ENG-PPR19042-R1-GEC-CDs-Redlines.pdf Markup Summary

Subject: EPC ENG Review
Page Index: 1
Date: 10/3/2019 11:15:45 AM
Author: dsdrice
Color: 
Layer:
Space:
Page Label: [1] GR01

GRADING AND EROSION CONTROL PLAN

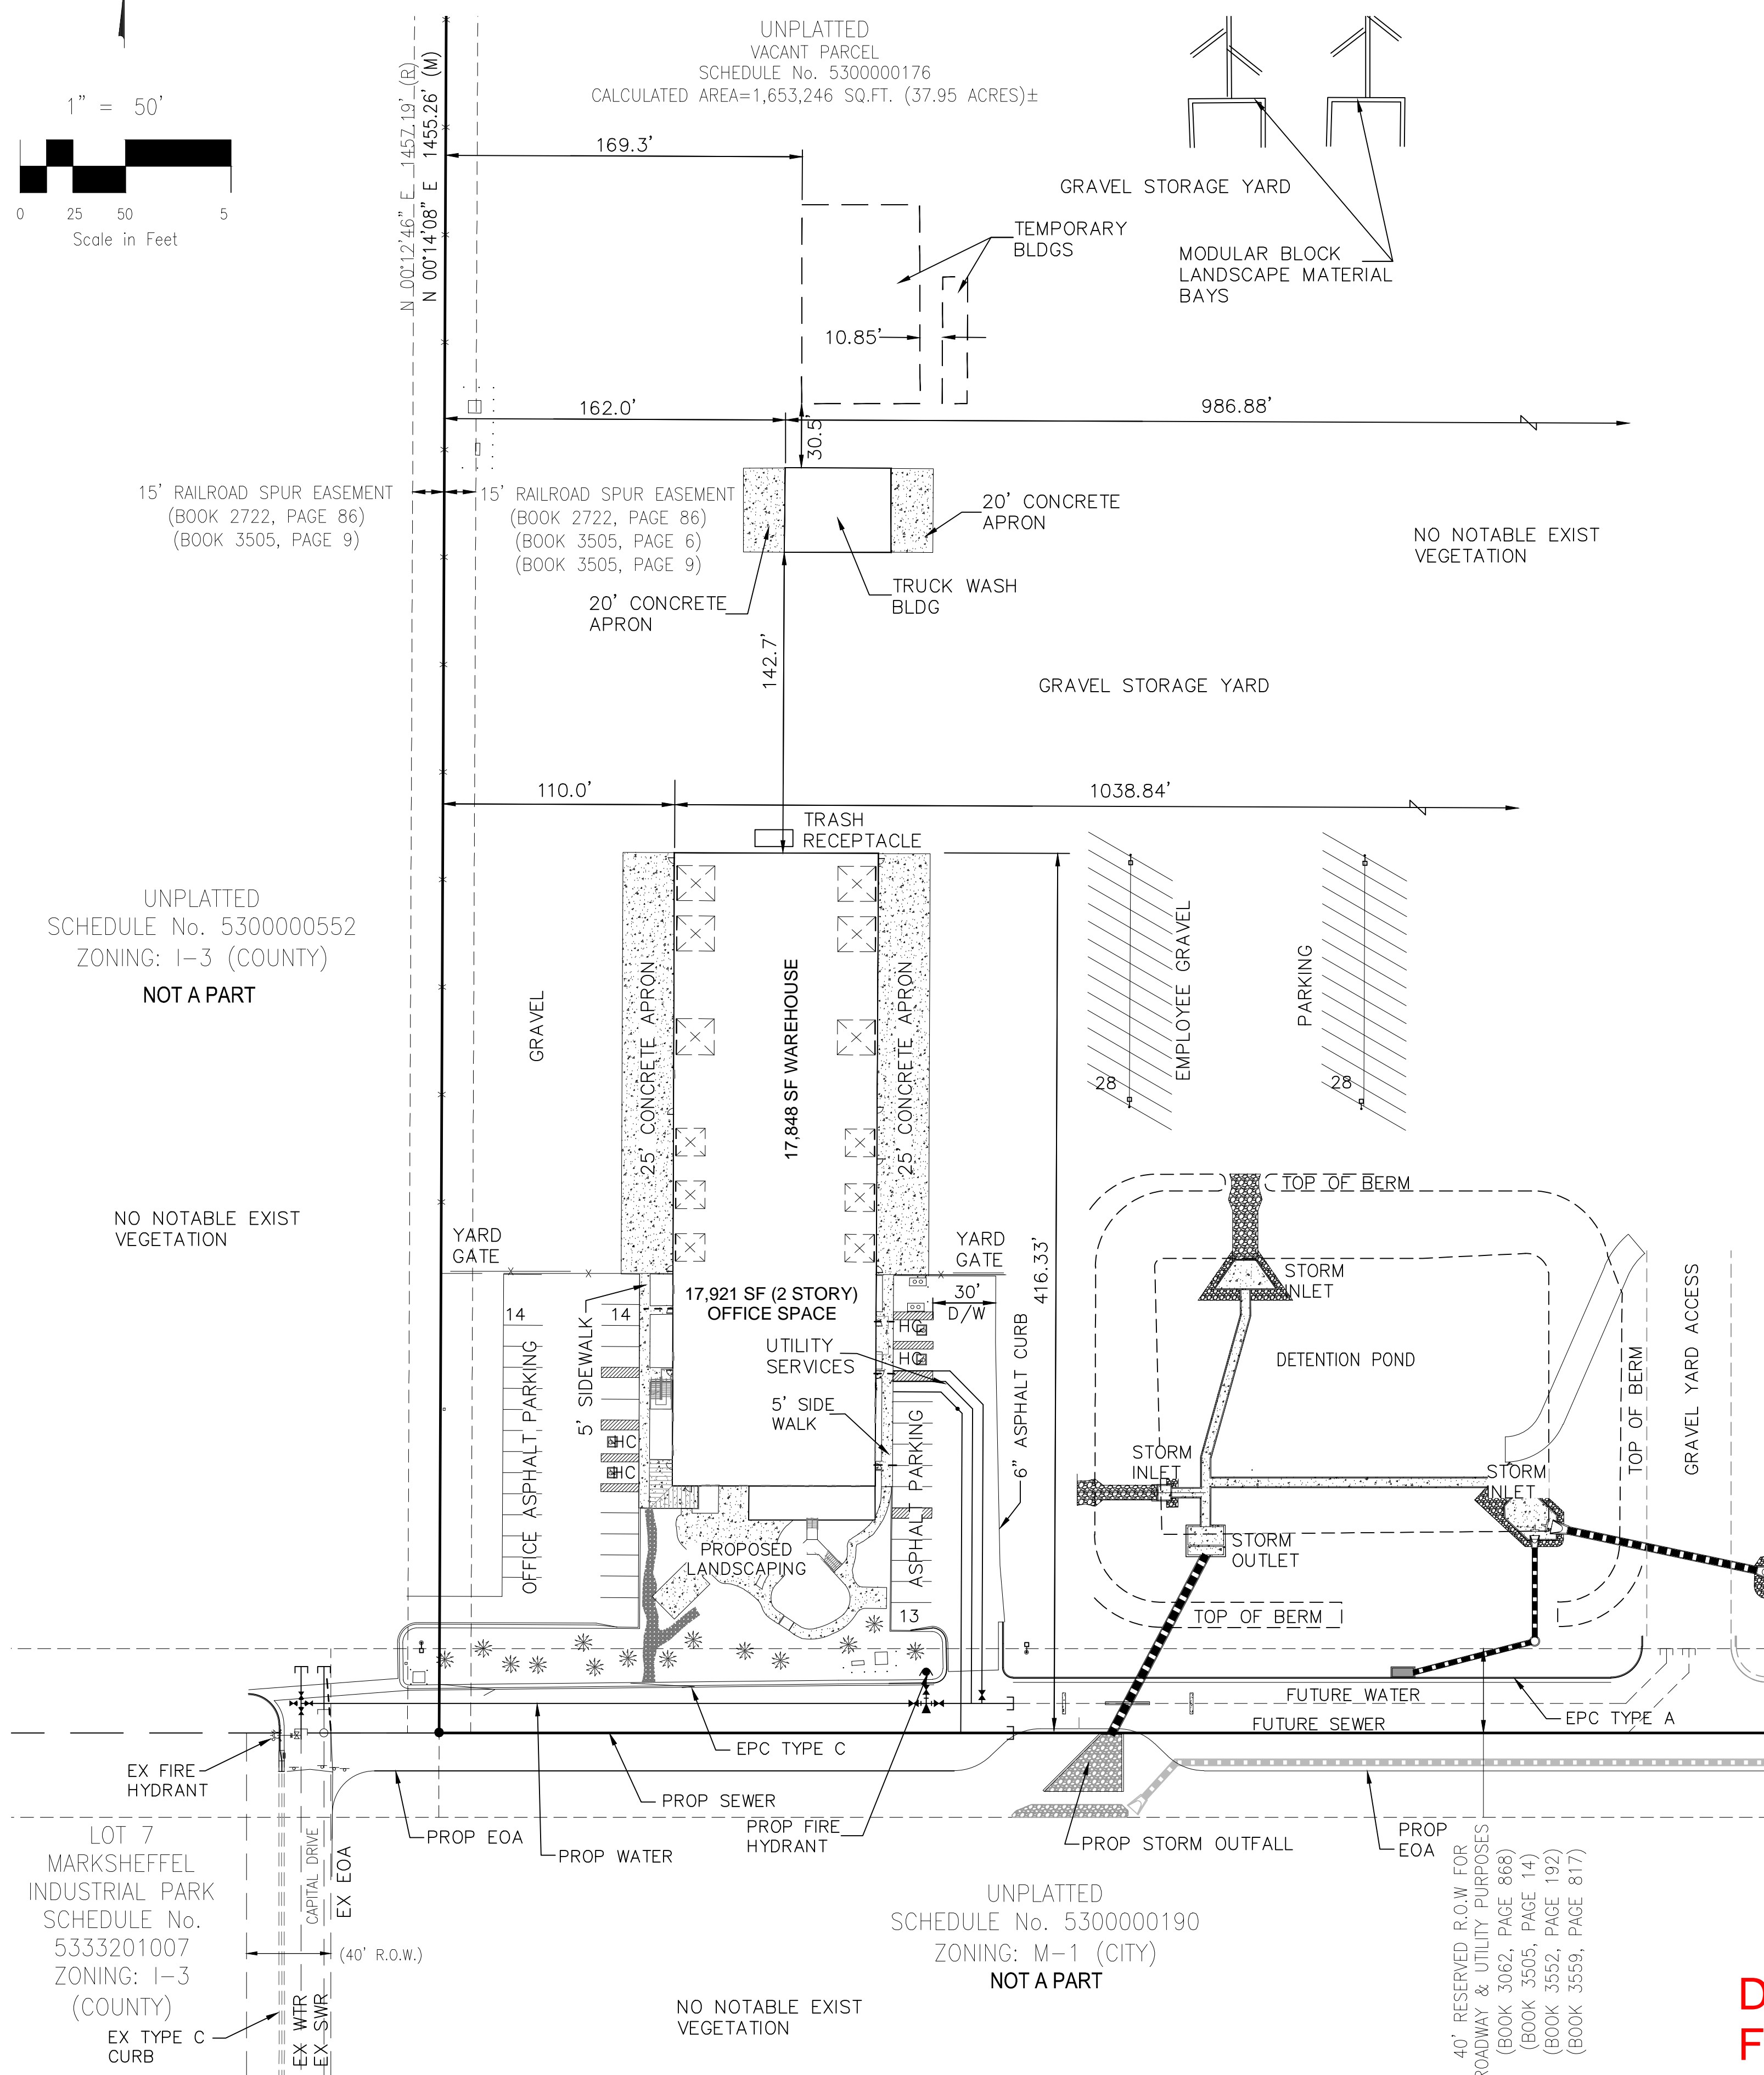
| <div>NO NOTABLE EXIST VEGETATION prairie grasses...?</div> <div>SITE A</div> | <div>Subject: Text Box</div> <div>Page Index: 1</div> <div>Date: 10/1/2019 2:11:54 PM</div> <div>Author: dsdrice</div> <div>Color: </div> <div>Layer:</div> <div>Space:</div> <div>Page Label: [1] GR01</div> | <div>prairie grasses...?</div> |
| <div>EL PASO COUNTY PLANNING AND COMMUNITY DEV. 2880 INTERNATIONAL CIRCLE, S COLORADO SPRINGS, COLORADO GILBERT LA FORCE, P.E. 719-520-7945</div> <div>CIMARRON HILLS FIRE DEPARTN 1835 TUSKEGEE PLACE COLORADO SPRINGS, CO 809</div> | <div>Subject:</div> <div>Page Index: 1</div> <div>Date: 10/1/2019 2:37:14 PM</div> <div>Author: dsdrice</div> <div>Color: </div> <div>Layer:</div> <div>Space:</div> <div>Page Label: [1] GR01</div> | <div>delete</div> |

GRADING AND EROSION CONTROL PLAN

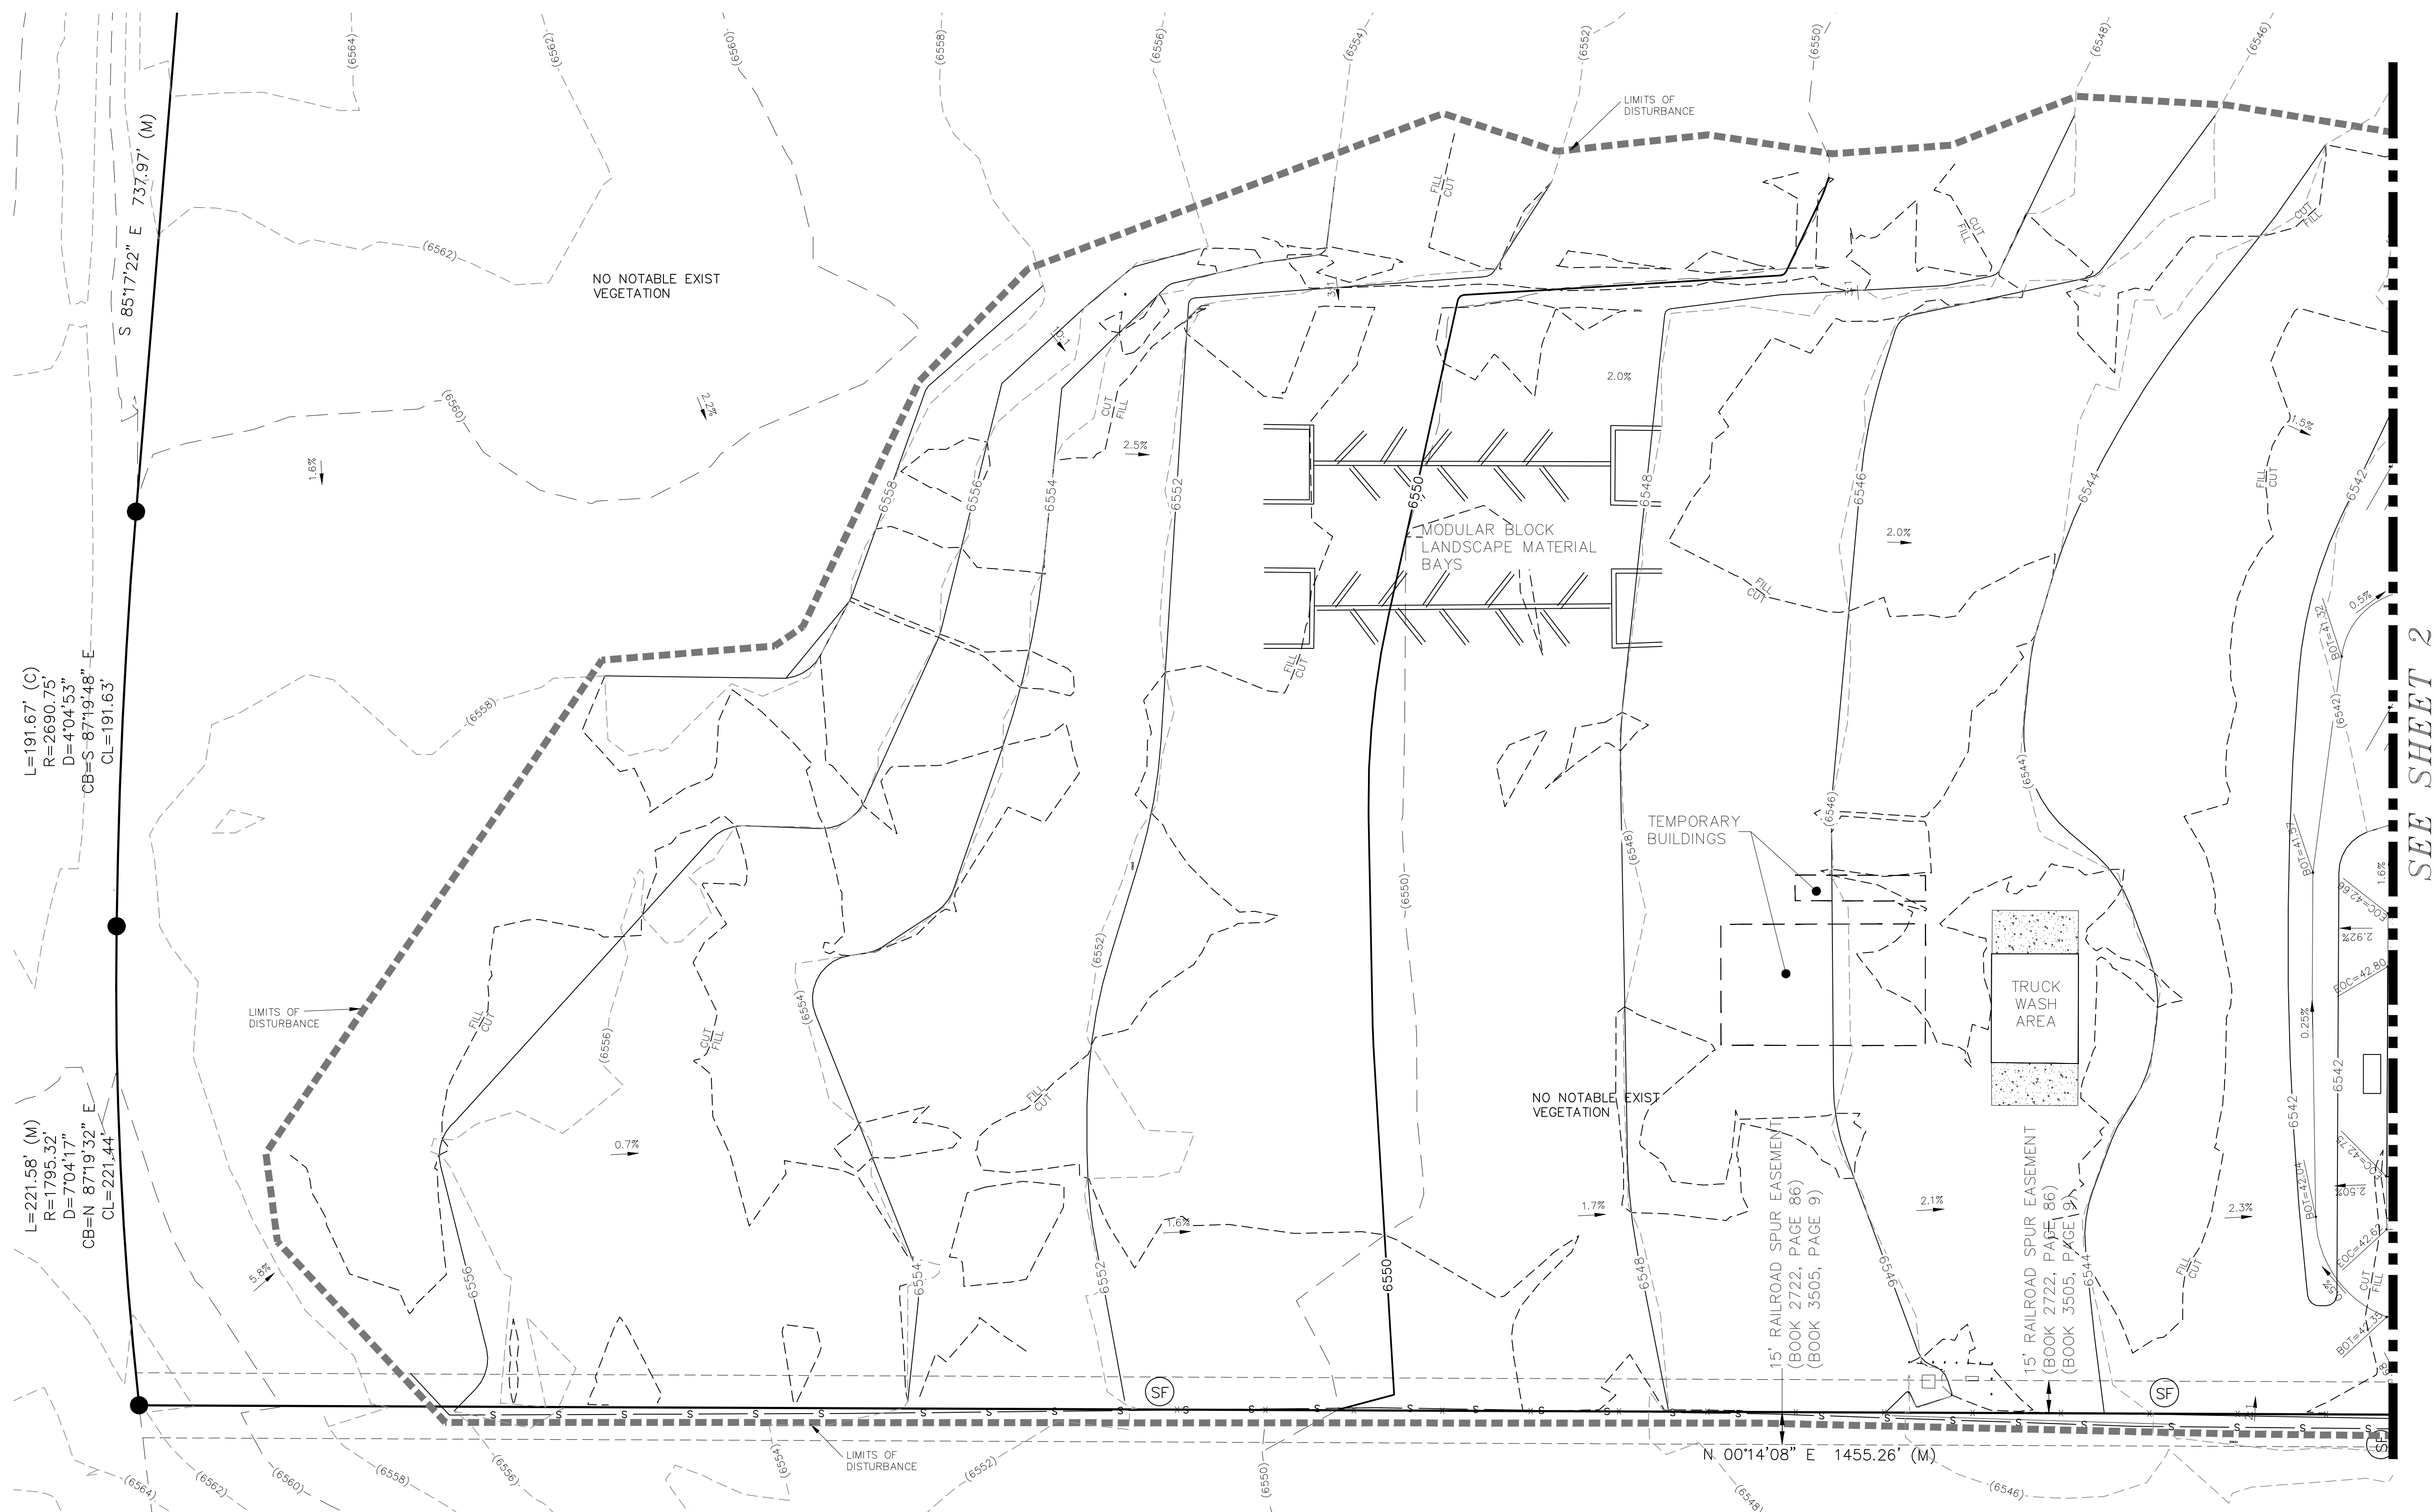
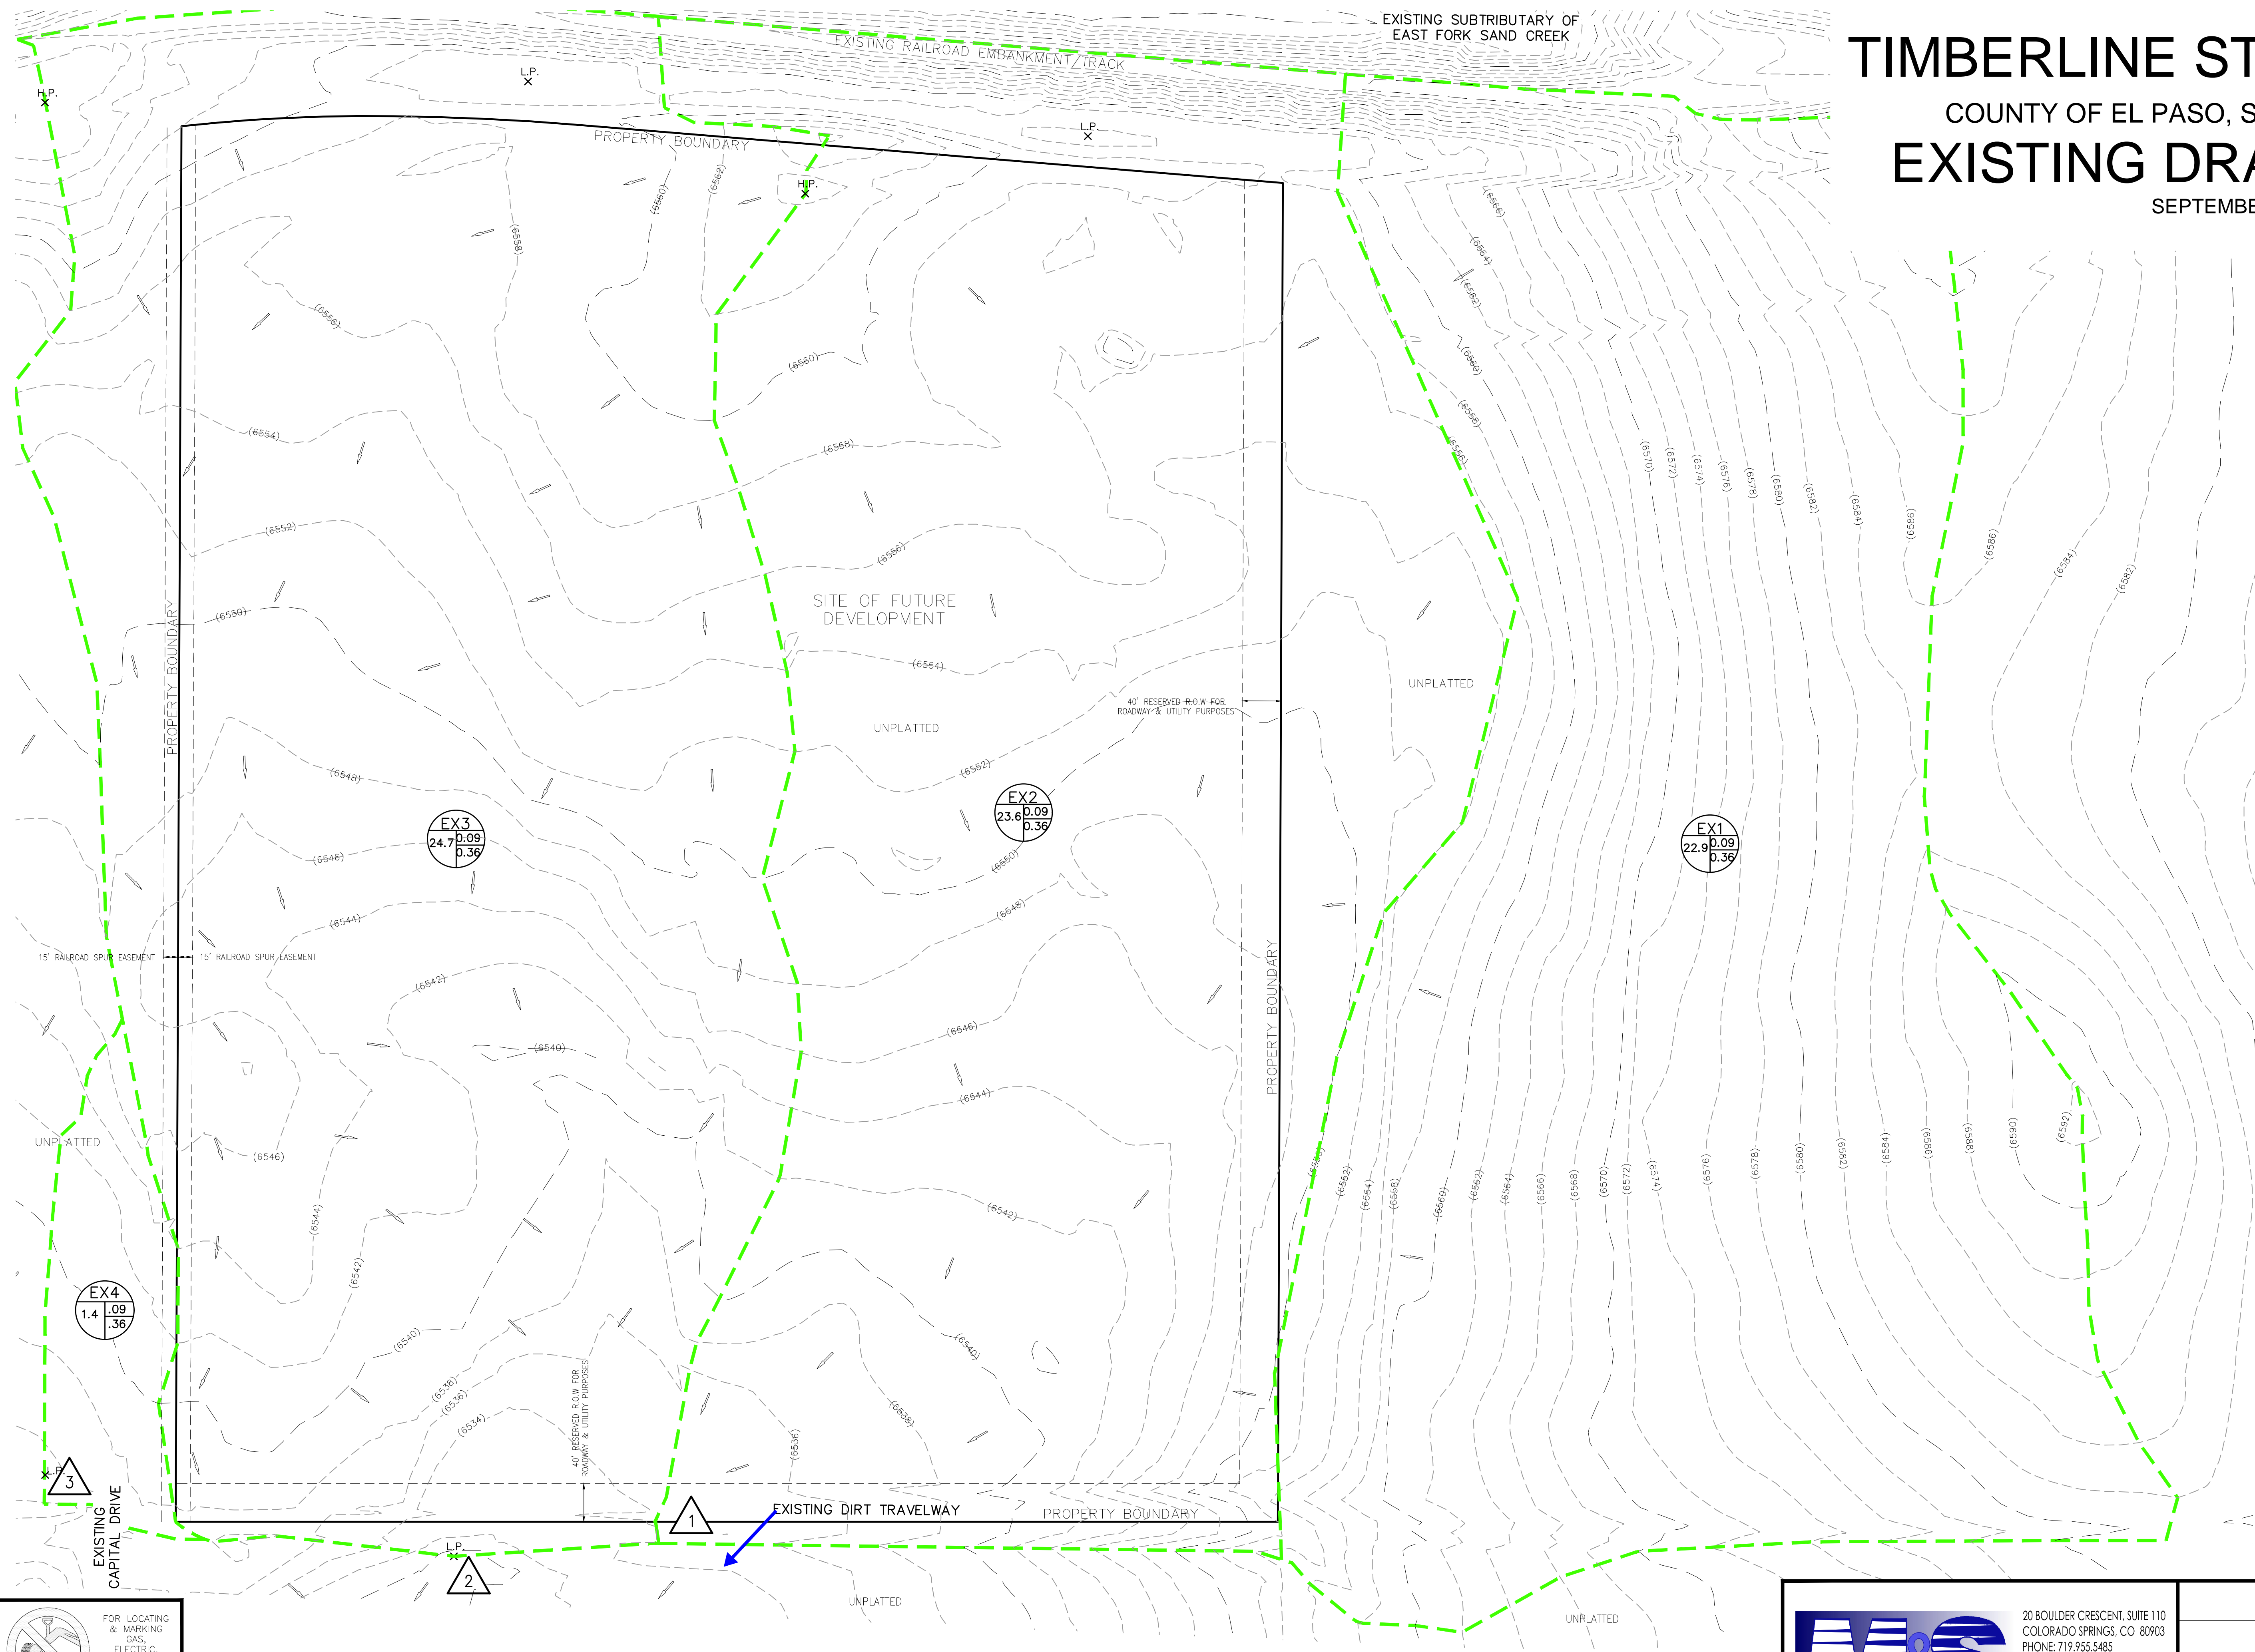
provide all linetypes

sediment berm?

is there fill here?

provide flow/slope arrows

provide seeding and mulching

Provide road cross-slope arrows and slopes.

remove future items

Is this EOP future or proposed? Label all proposed surfaces.

LOD?

Provide report for this site.

provide flow/slope arrows
